Recommendation Report for Lawful Development Certificate for a Proposed Use or Development

REF NO: FG/194/21/CLP

LOCATION: 25 Colindale Road North
Ferring
BN12 5LB

PROPOSAL: Lawful development certificate for a proposed loft conversion to existing property to include dormer to rear of property.

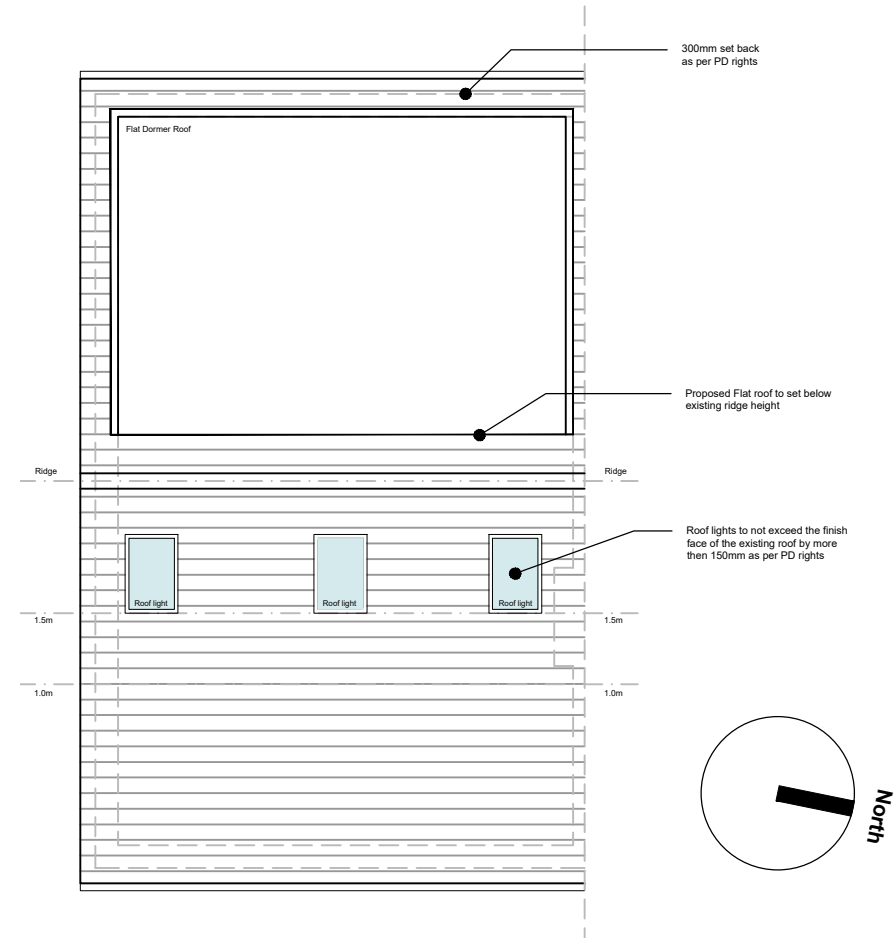
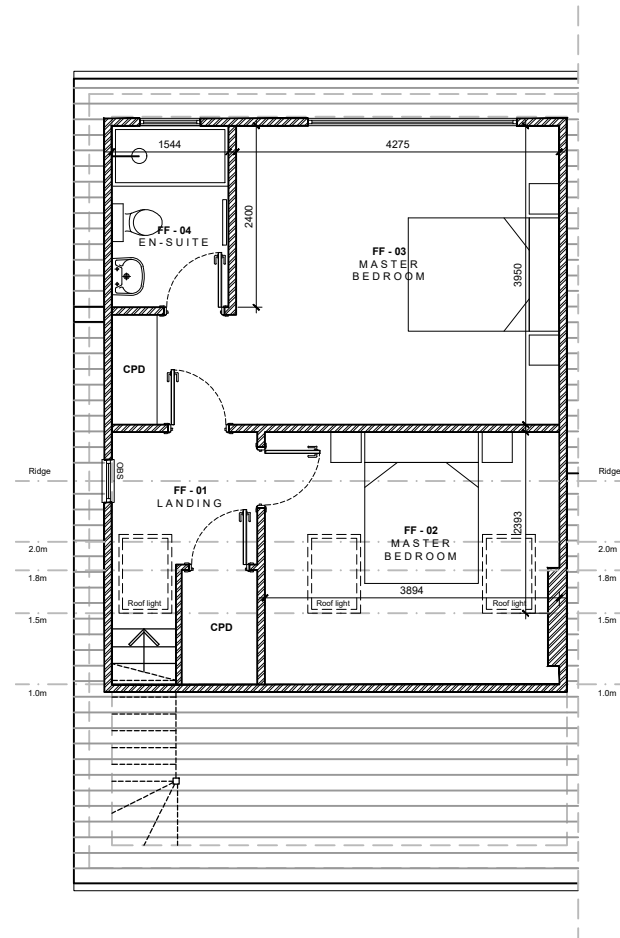
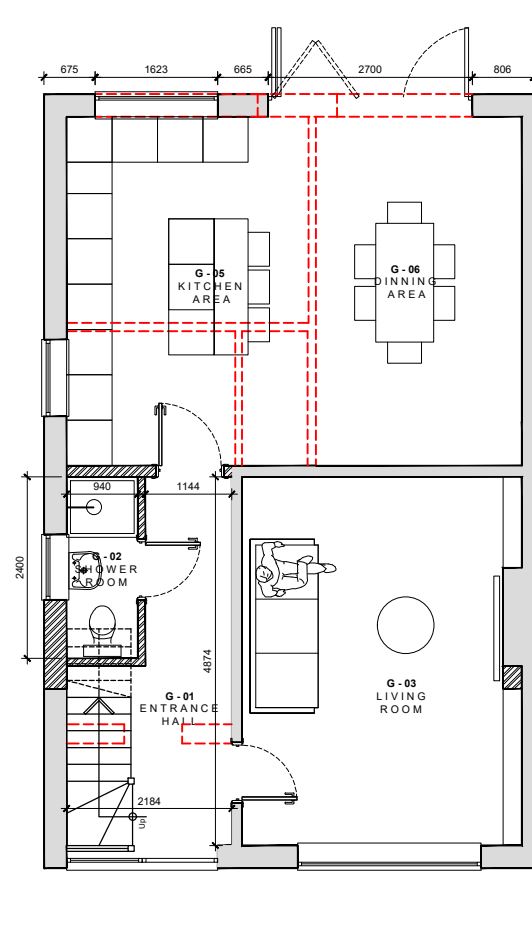
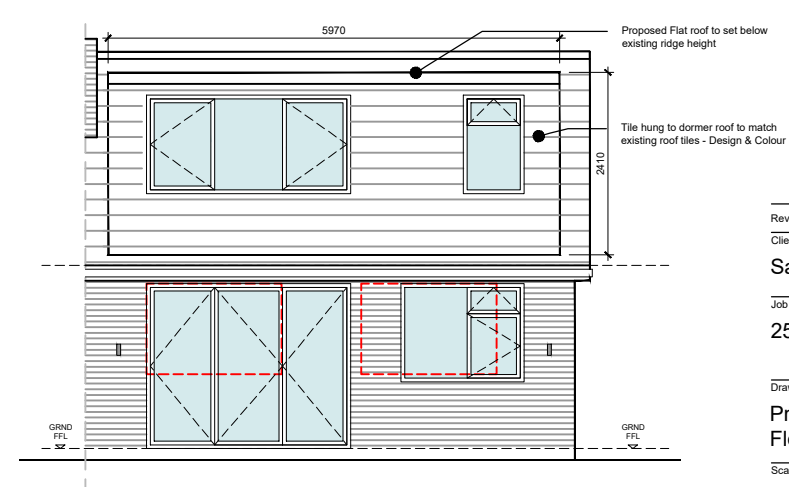
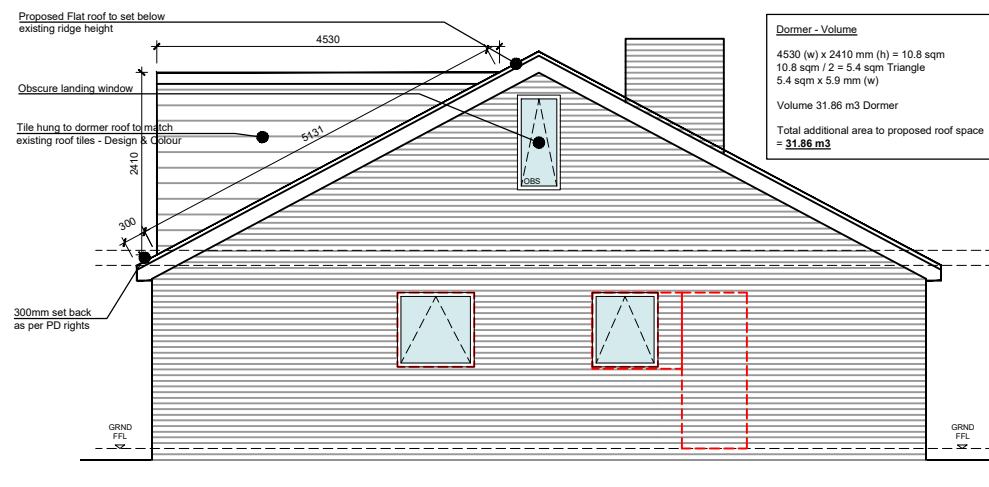
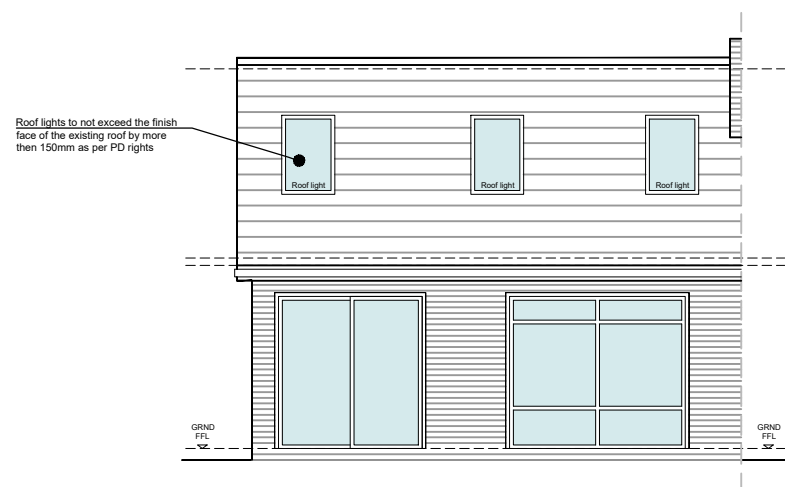
The proposed rear roof dormer conflicts with relevant sections B.2 (c) in that the window will be openable below 1.7m above finished floor level, and is not considered permitted development and as such does require the submission of an application for full planning permission.
